Your Ref: OWPC20981
Our Ref: EP/166/18/HH 13-11-2018
Please ask for:
Zac Denton

Erection of a two storey rear extension, second storey enlargement of side dormer and conversion of garage to study including demolition of existing conservatory
100 Sea Road East Preston

Thank you for your internet representation made on 2nd January 2019 which has been recorded as '**an objection**' with the comments as follows:

Proposed Floor Plans,
Elevations, Roof Plan and
Block Plan

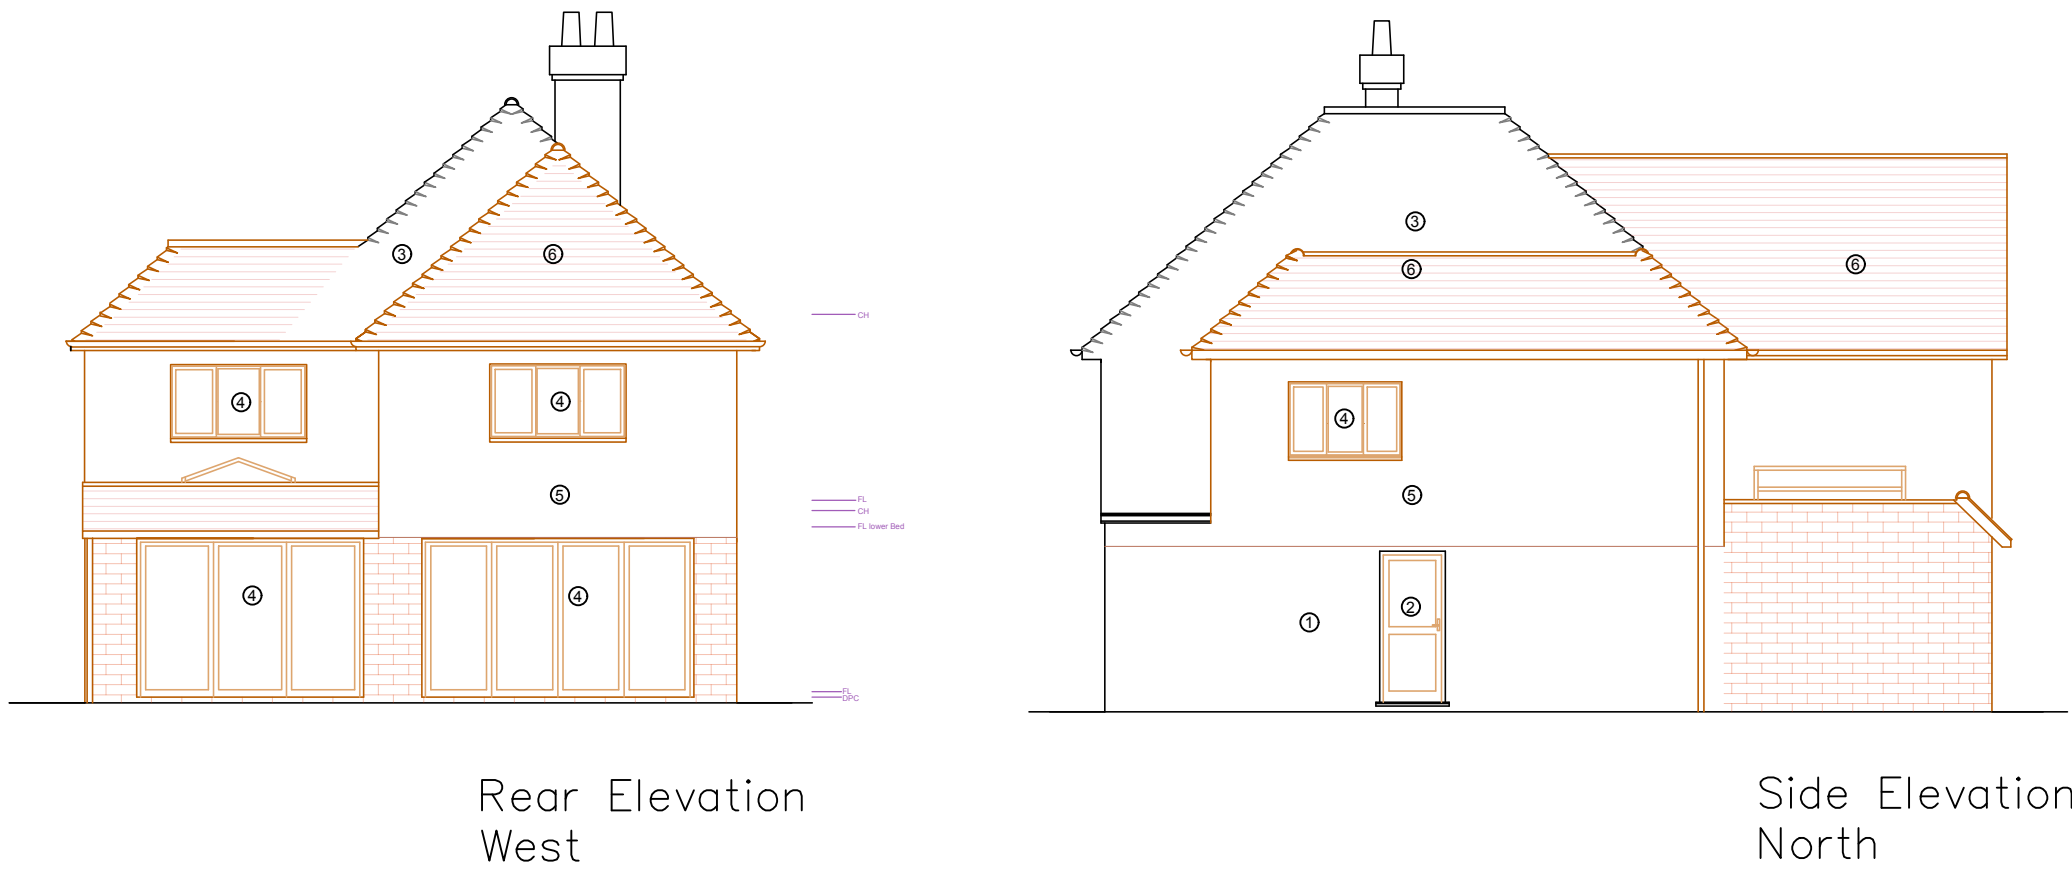
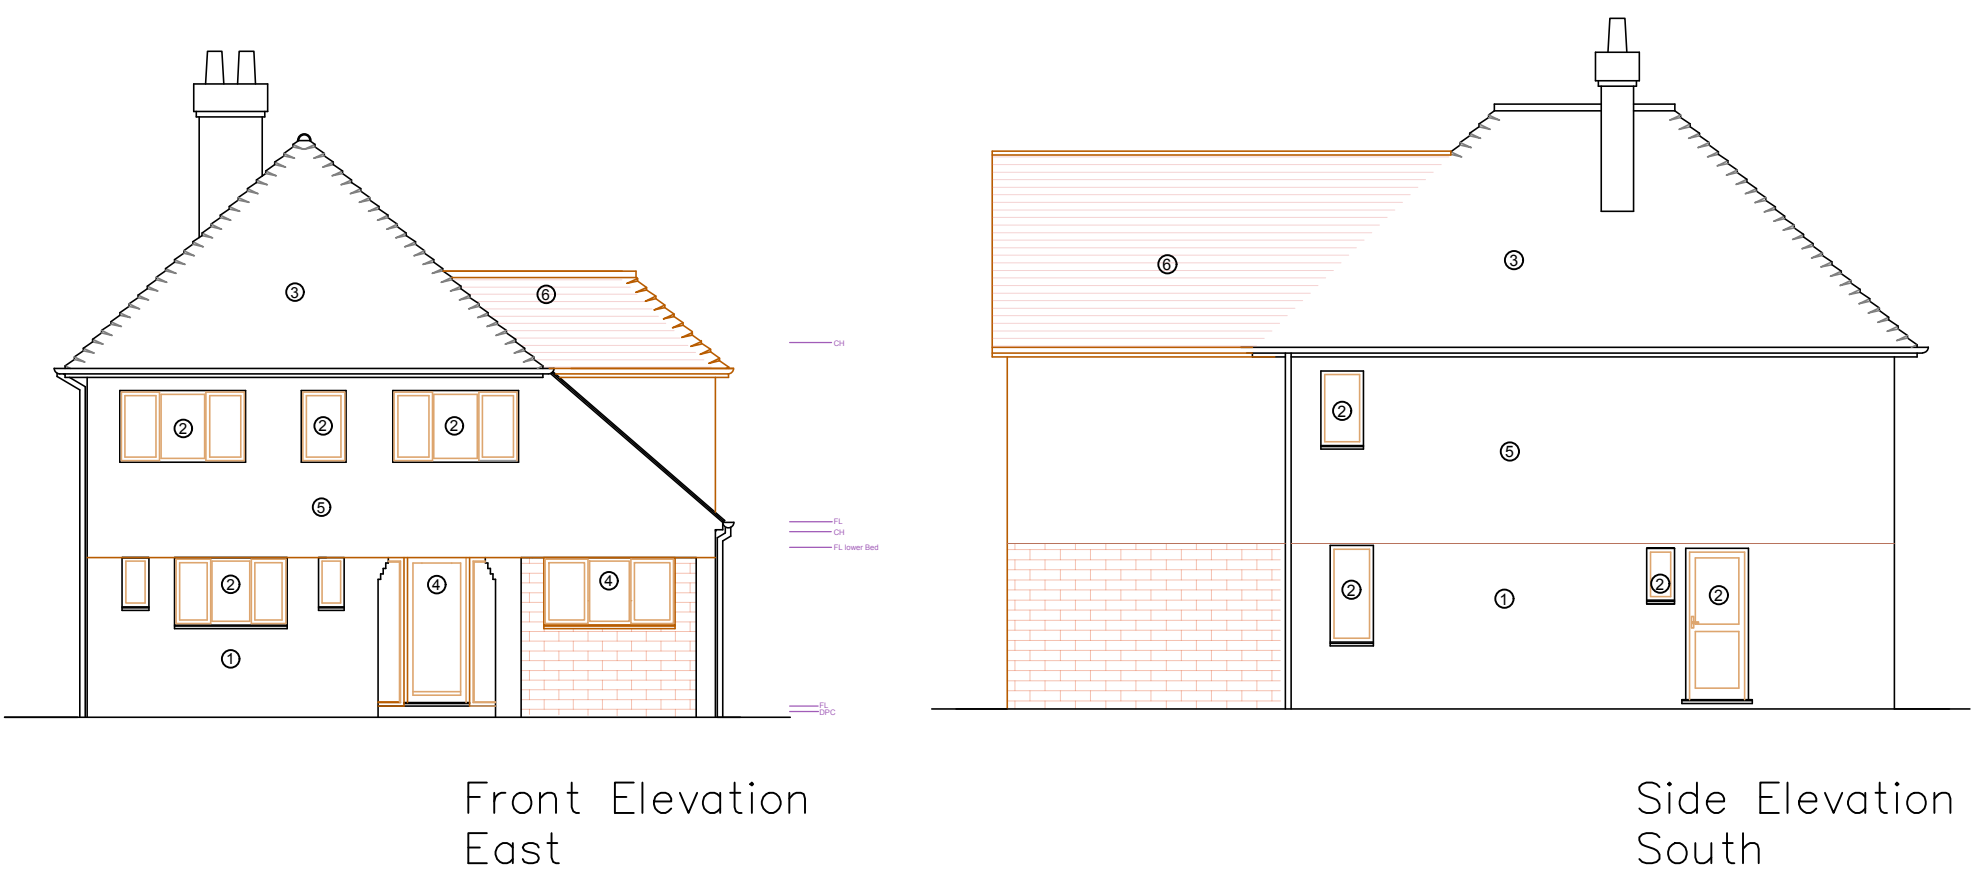
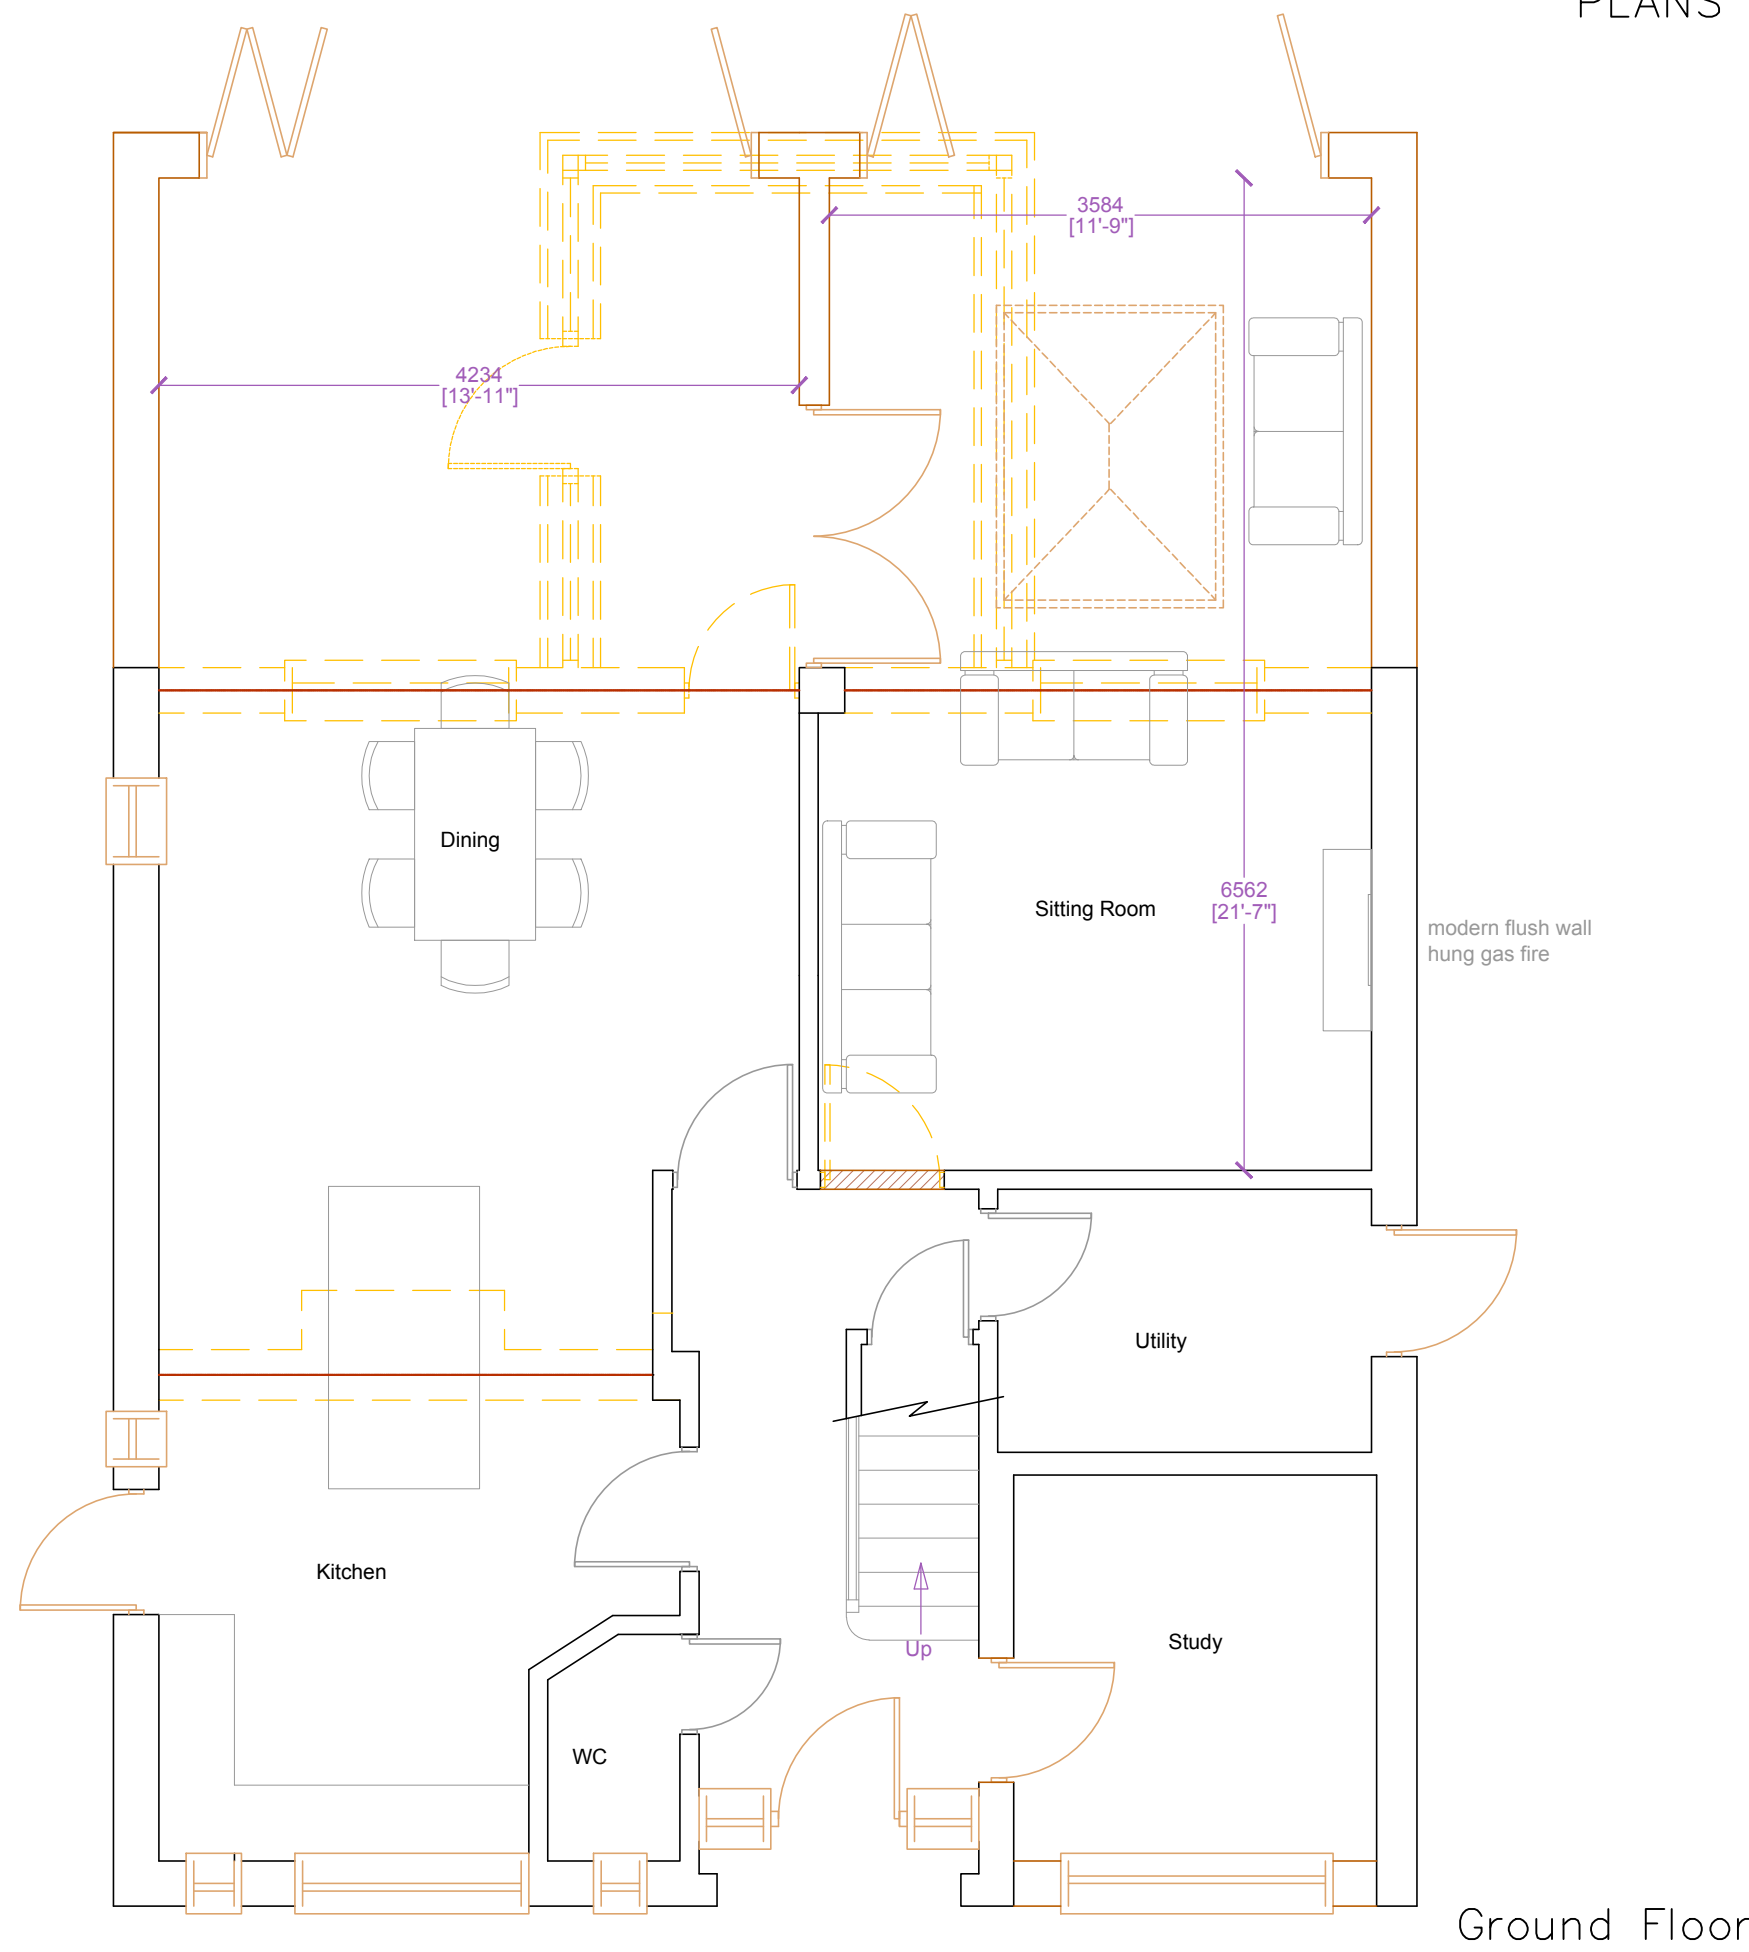
A two storey develop outside the envelope of the existing property is an over-development of the site. It will be far too overbearing for neighbouring properties in particular 102 Sea Road. The council has continually informed residents of Sea Road that any size of 2 storey extension would be out of the question due to their overbearing nature and suitability. We were informed of this when we had a discussion about extending our property where we were told that two-storey extensions at the back of properties would be refused. Support to the application would set a dangerous precedent for the street and is also not in line with the Neighbourhood Plan and the East Preston Conservation Society.
